Application for Planning Permission for Works or Extension to a Dwelling

Development: SINGLE STOREY REAR EXTENSION TO REPLACE CONSERVATORY.
PART CONVERSION OF REAR OF INTEGRAL GARAGE INTO HABITABLE SPACE

Location: 22 Windsor Drive Rustington BN16 3SW

Block Plan

SITE PLAN 1:500 @ A4

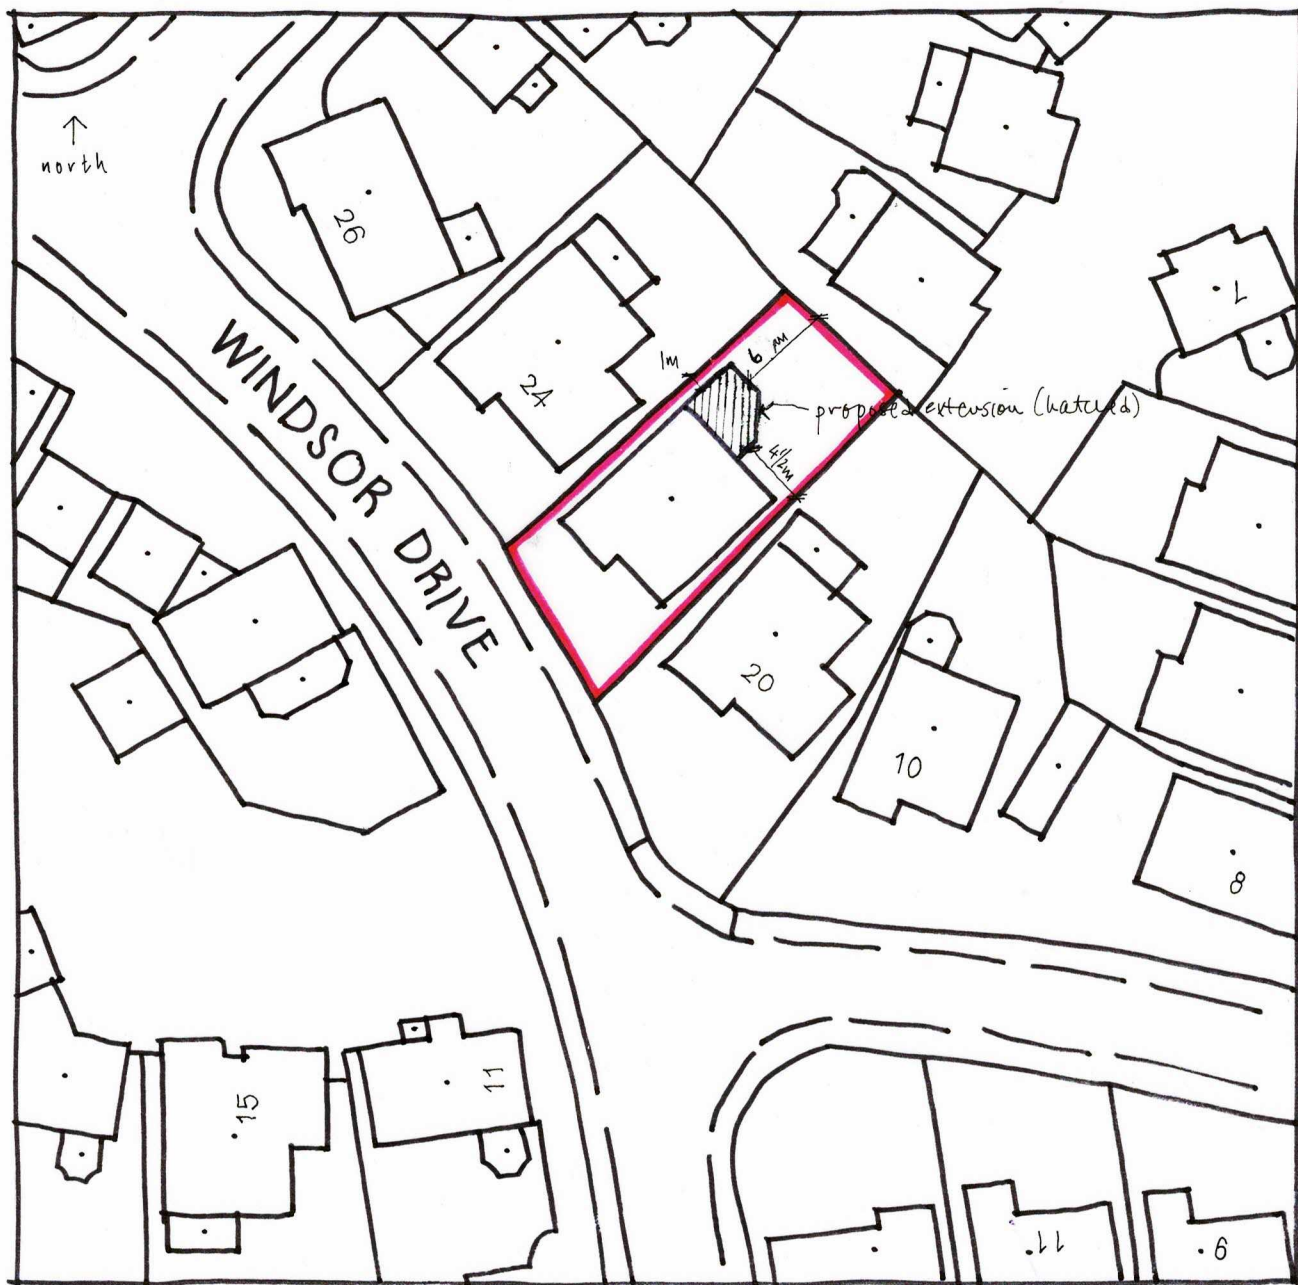
The dimensions on the block plan do not measure to scale, please amend. Further details of what must be included on the plan can be found in the Validation Requirements List.
